**To:** Grant Greene-Smith  
**Subject:** RE: Caltex Kurnell Refinery - Demolition and Removal of Redundant Infrastructure - Notice of Exhibition

**Proposal: SSD5544\_MOD1 - Modification Application for the Demolition of Redundant Infrastructure at the Kurnell Terminal (160-166 Captain Cook Drive, Kurnell)**

**Caltex Kurnell Refinery Conversion (SSD\_5544 Mod 1)  
Proposed Modification**

**KURNELL REFINERY CONVERSION  
DEMOLITION AND REMOVAL OF REDUNDANT INFRASTRUCTURE (SSD 5544 MOD 1)  
NOTICE OF EXHIBITION**

Figure 2: Proposed Demolition Works at the Caltex Terminal, Silver Beach and Botany Bay

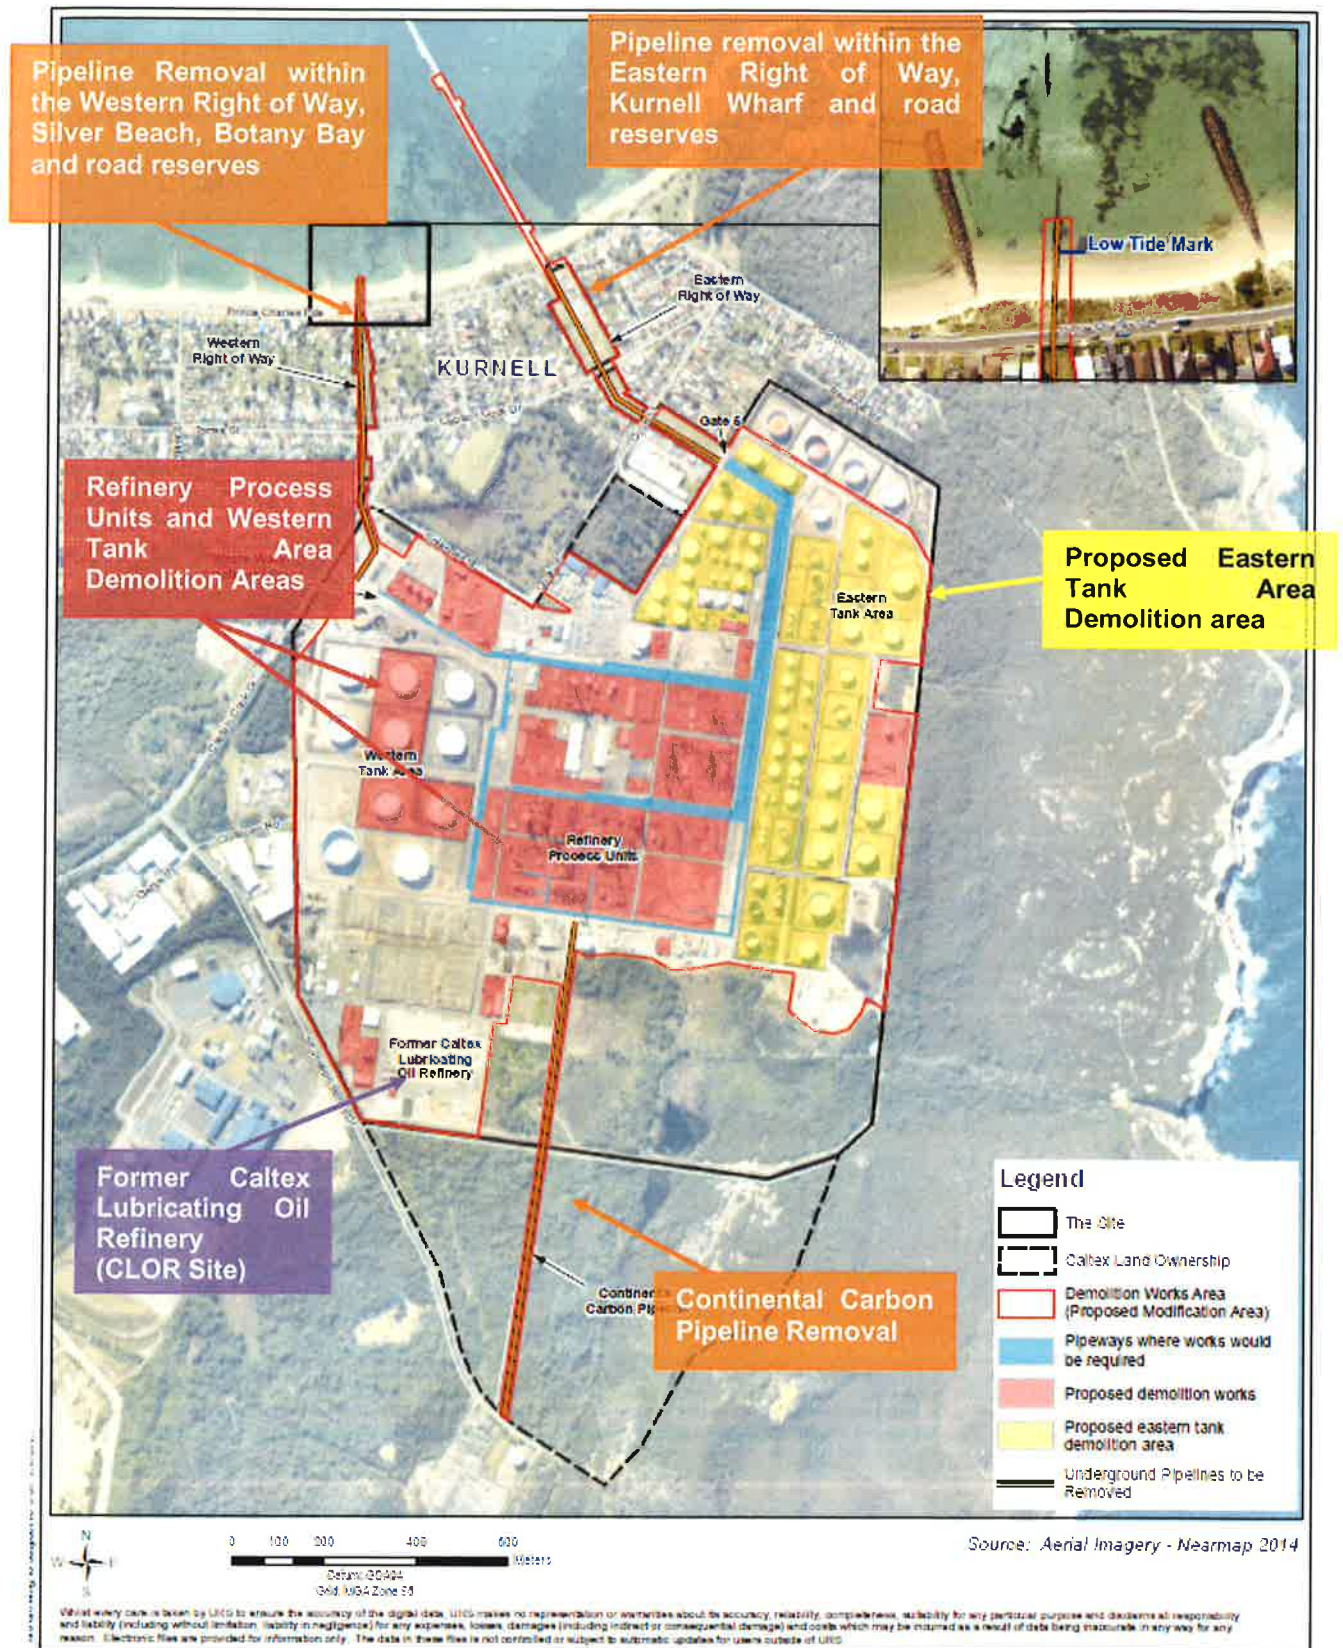
In light of the recent pollution event concerning the cooling water outlet pipe (where oil was discharged into the bay through the pipe) a contamination assessment of the sediments surrounding and beneath the pipe should be undertaken and any contaminated sediments remediated to remove the contamination.

It has been identified that there is the potential for erosion of dune sands for a period of up to 2 weeks following removal of the cooling water outlet pipe. Measures need to be put in place to prevent erosion during this time, and long term stabilisation of the dune sands will need to be implemented.

5. Given its sensitive location a specific Management Plan should be considered for the removal of the cooling water outlet pipeline in Caltex’s right of way and at Silver Beach.

Section 9.6.1.2 states that the removal of the cooling water outlet from below low tide mark would result in the disturbance of sediments within Botany Bay. Given the recent incident involving the discharge of hydrocarbons from this pipe, Caltex will need to consider and implement appropriate management measures to address this issue. The marine growth and associated sediments on top of the pipe may also be impacted by hydrocarbons and will need to be considered.
